RE: 2025/92388 (JCNAS 209837) | Red House Museum, 281 Oxford Road, Gomersal, BD19 4JP (Grade II*, c.1660, with C18, C19 and C20 alterations). Application for subdivision into two residential units and conversion of barn and coach house into third residential unit.

Thank you for consulting the Victorian Society on this application. Having considered the proposal carefully, we **raise serious concerns** to these plans in their current form.

Drawing Title
**Barn
Elevations as Proposed**

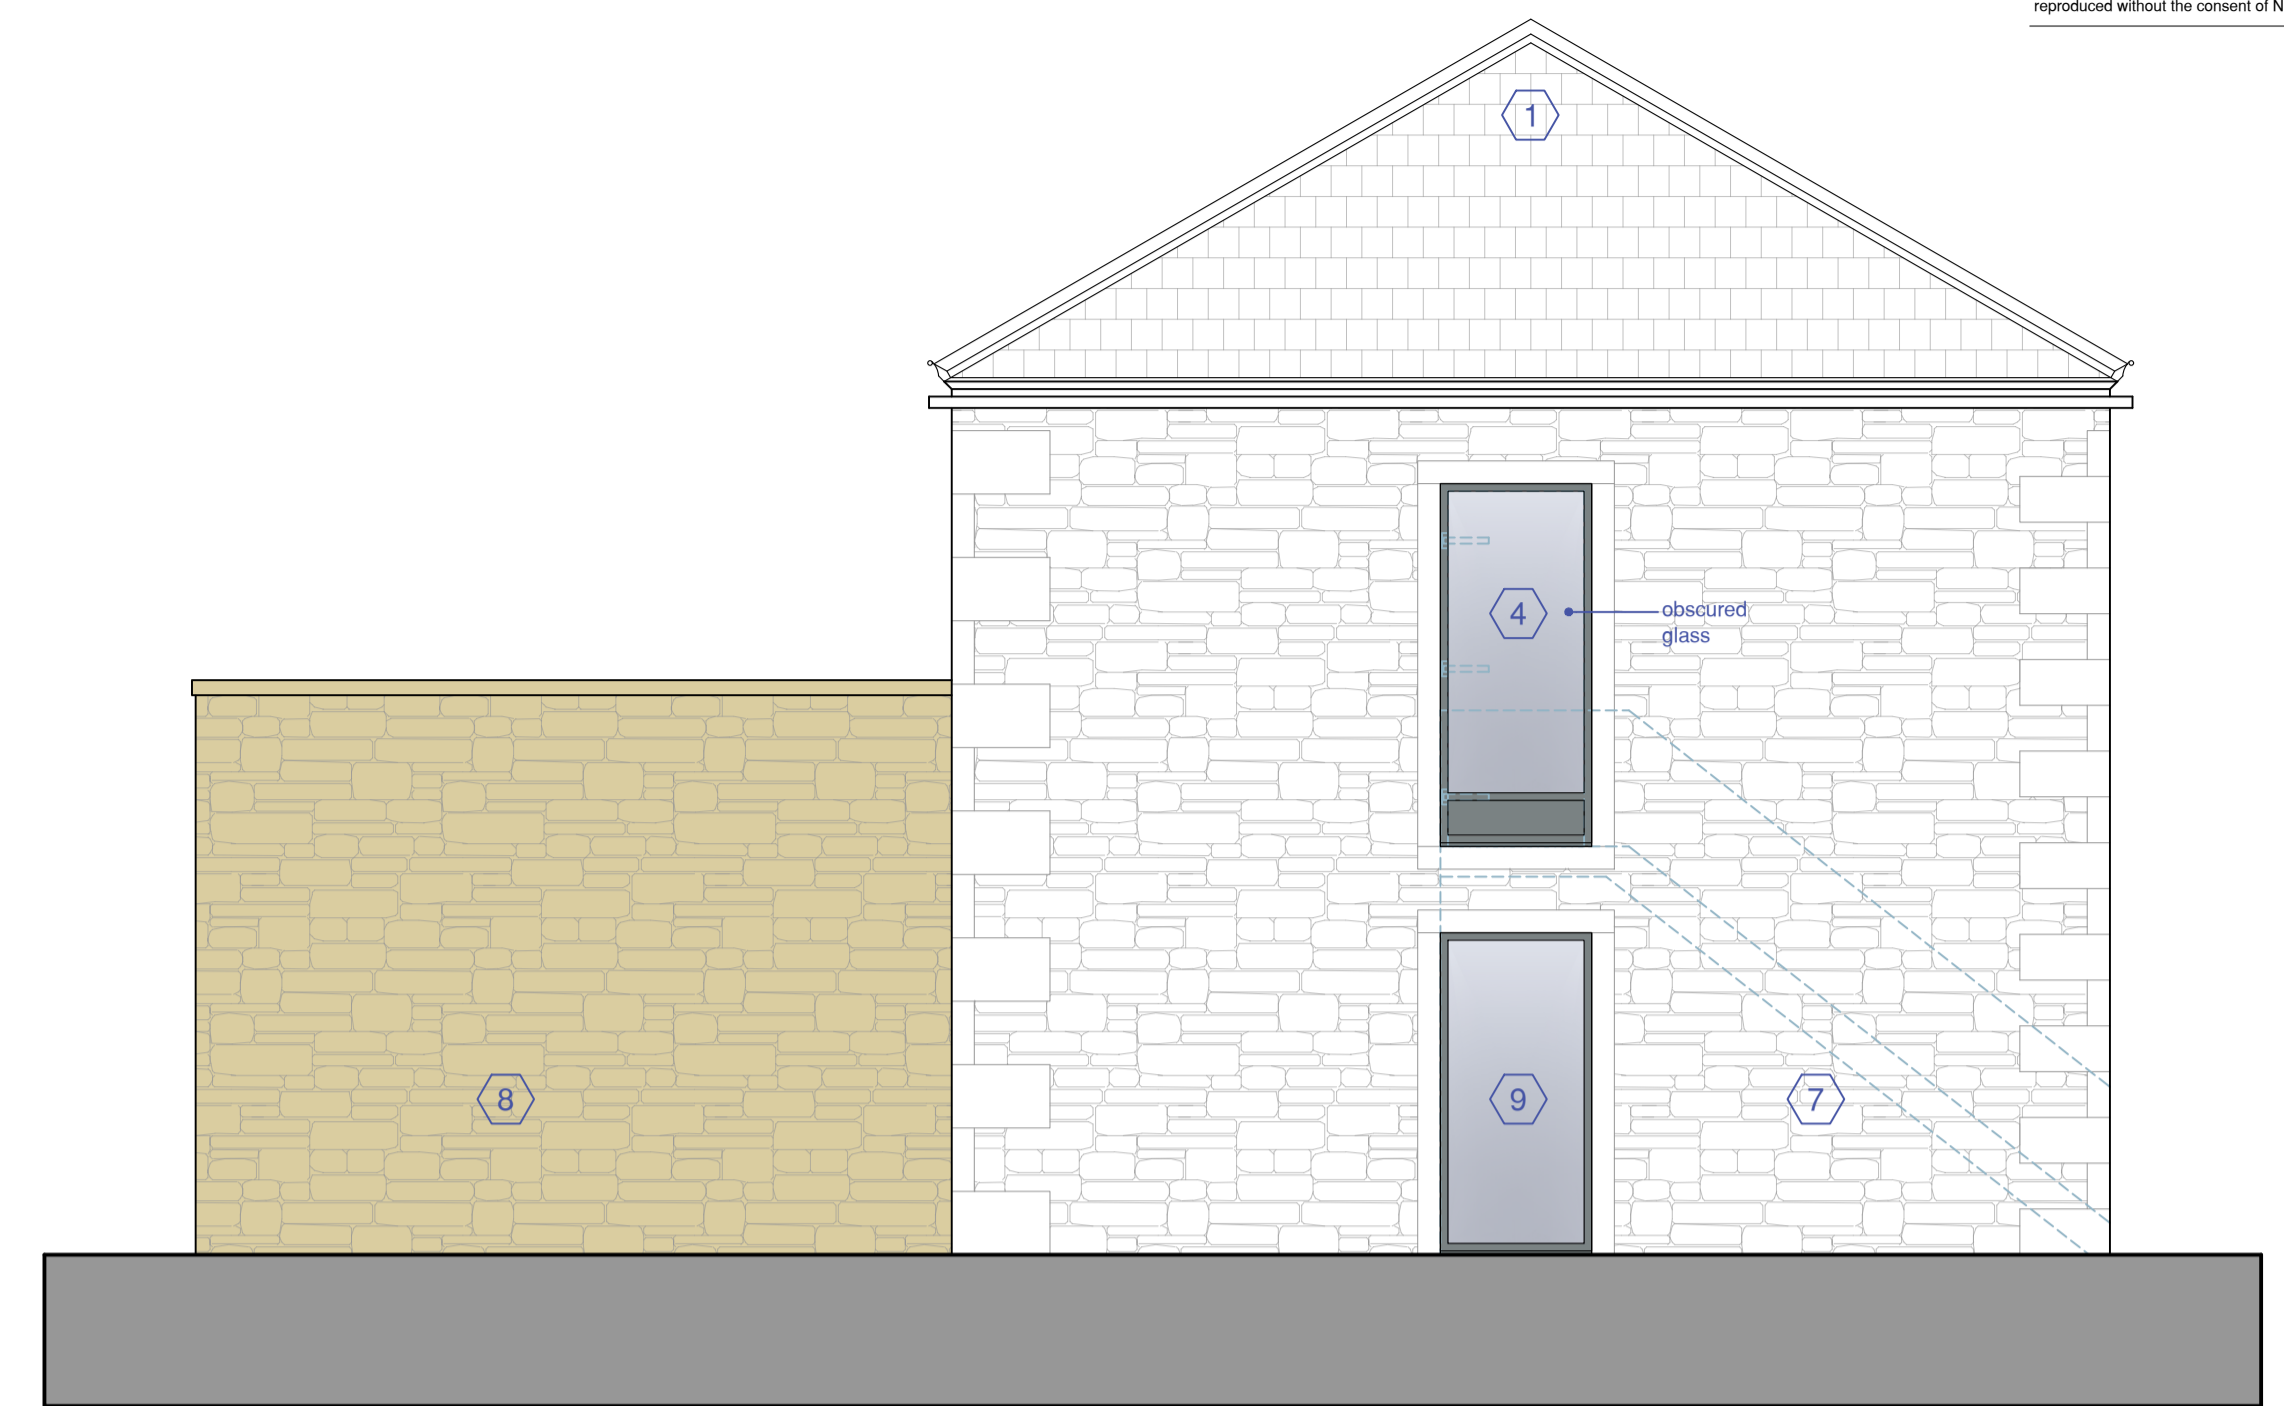
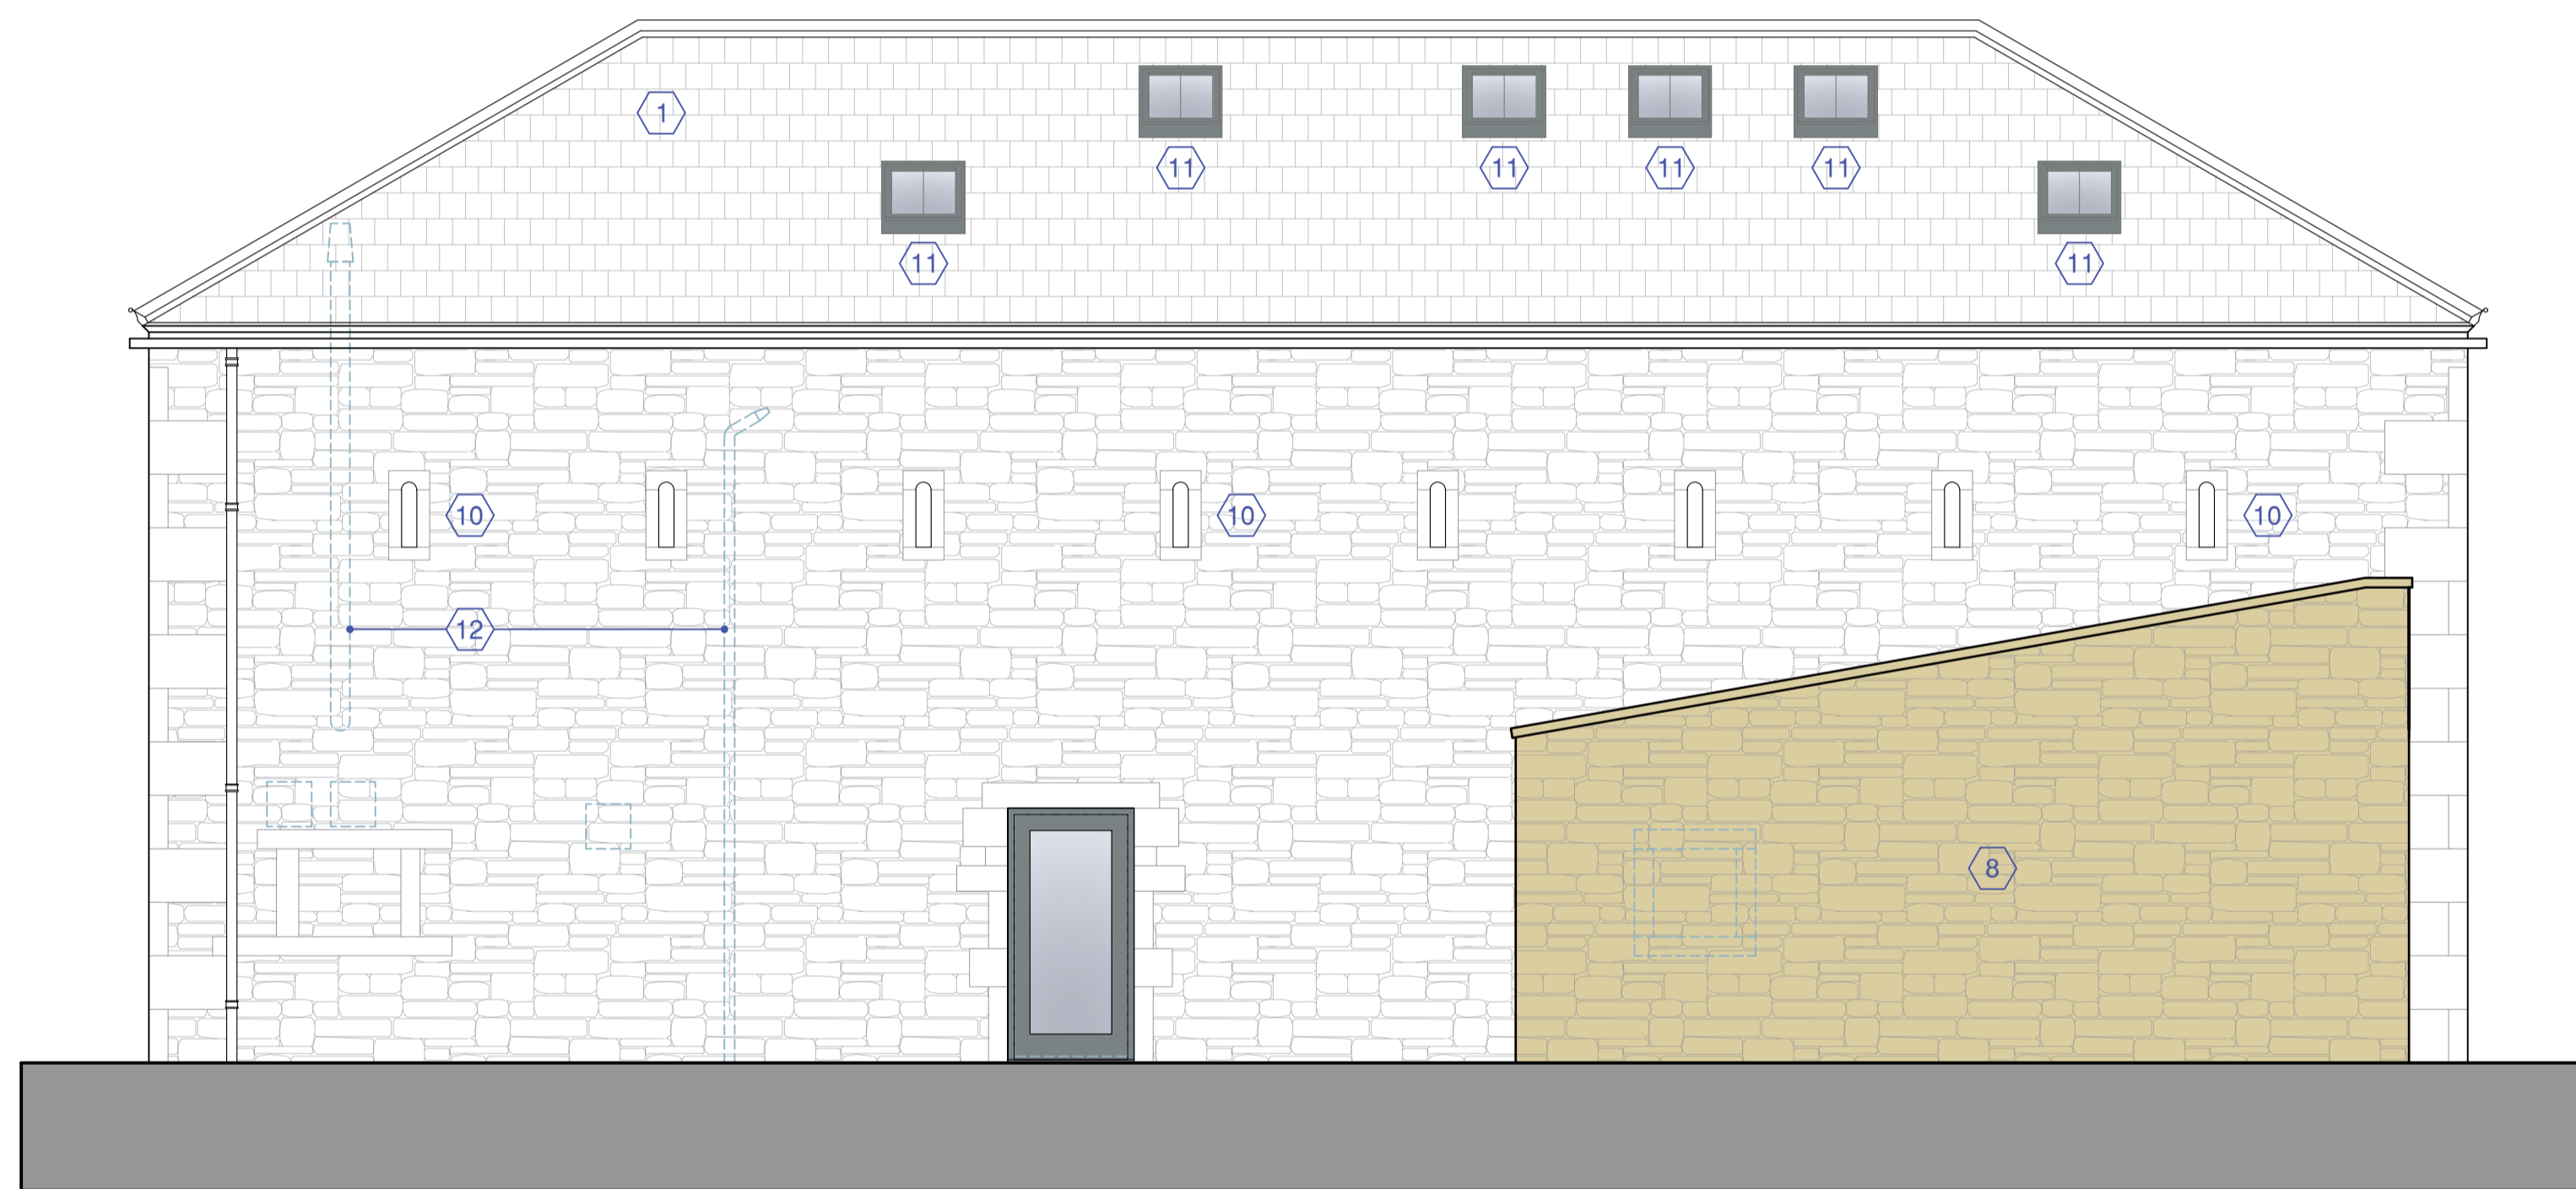
While we do not object to the principle of converting the barn and coach house into residential accommodation, we are concerned that they have not been treated as curtilage to the property and therefore lack the detail the alterations would require. We again request a deeper exploration of the impacts these proposals would have on the fabric, setting and relationship between the barn/coach house and main house.
